REPORT UPDATE

Application No: EP/90/09/

PLANNING APPLICATION REPORT**REF NO:** EP/90/09/**LOCATION:** Churchfield
Station Road
East Preston**PROPOSAL:** Demolition of existing buildings & residential redevelopment to provide 14 no. houses & apartments, with associated parking & open space.**SITE AND SURROUNDINGS**

Drawing no.
Site Layout & Context
O.120.08.100.A

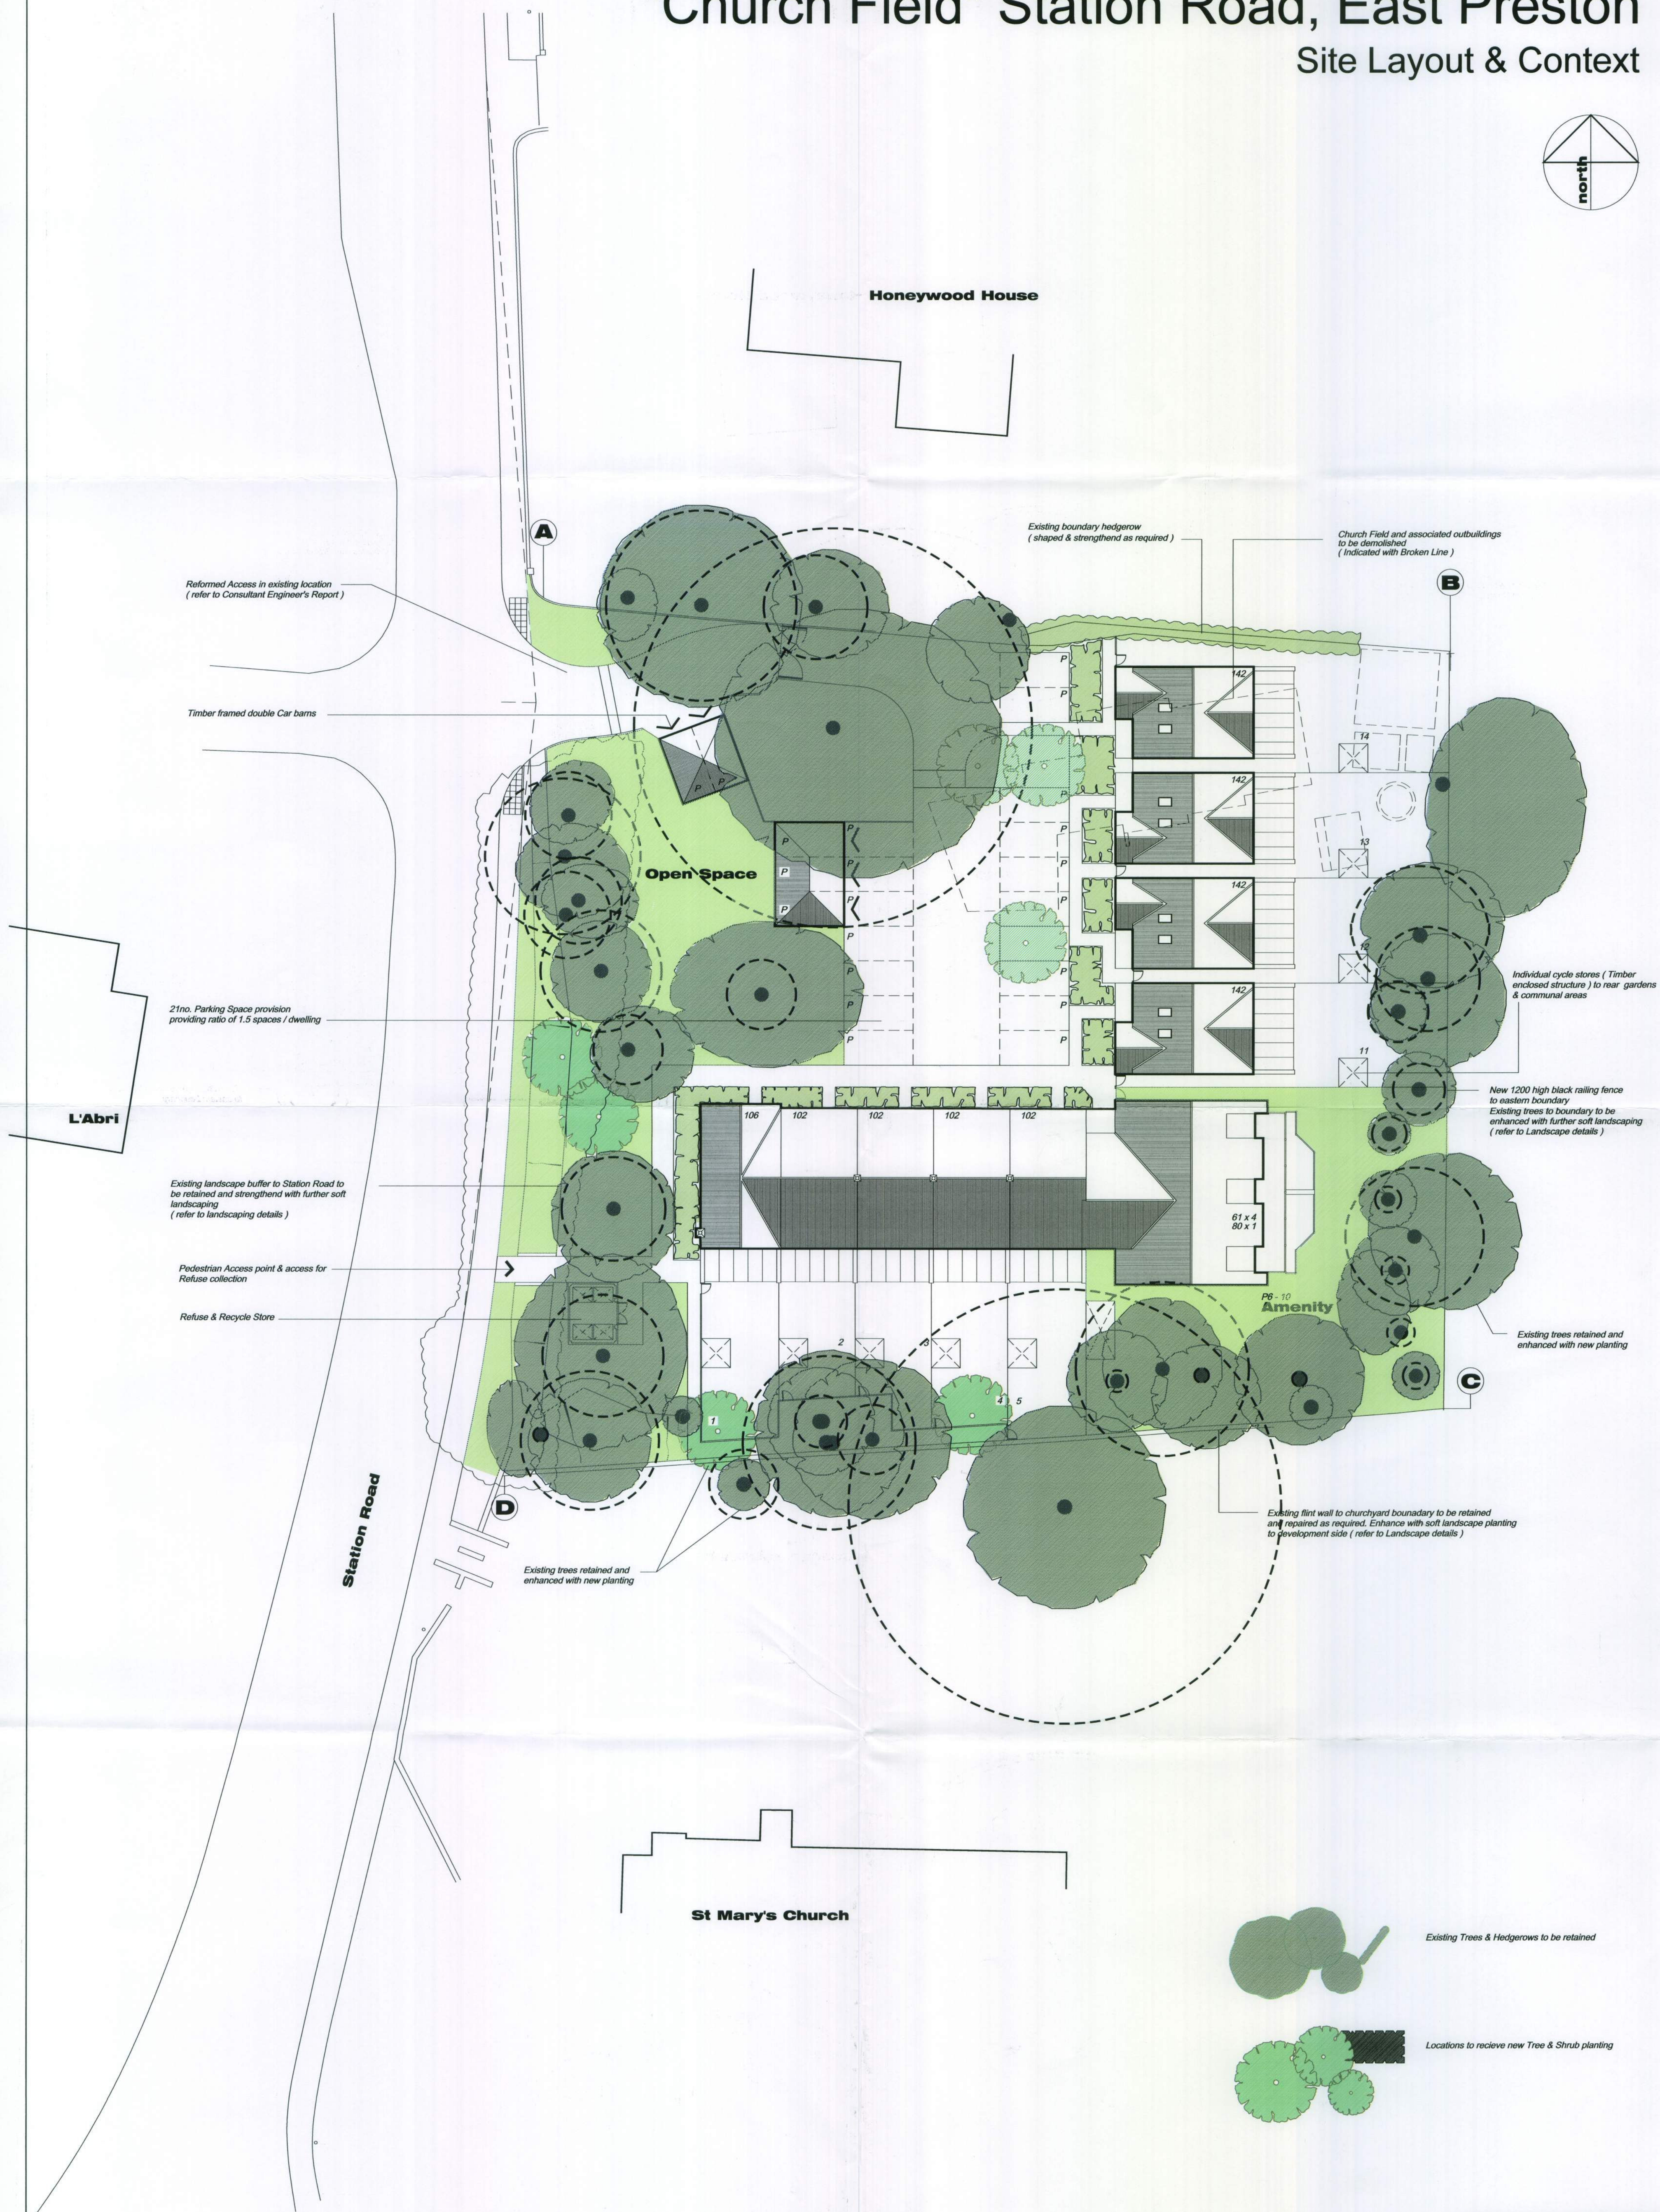
Objection - Rustington Parish Council. The proposal does not provide for vehicle parking in accordance with policy GEN12 of the Arun District Local Plan. 21 spaces is significantly lower than 33 that would be required for the development. This would lead to on-street parking which would interrupt the free flow of traffic and introduce hazards to highway users particularly on the bend. No defined turn on site. Precedent.

It should be reiterated that development for 14 no. residential units have previously been approved on this site and is extant. The previous application had 20 no. parking spaces, the current application has 21 no. spaces. The parking standards within the Arun District Local Plan are maximum provision. Indeed policy GEN 12 of the Local Plan states that the LPA may seek a lower provision than required by the standards for developments proposed in town centres and other areas accessible by other means of transport. There is turn on site provision within the development.
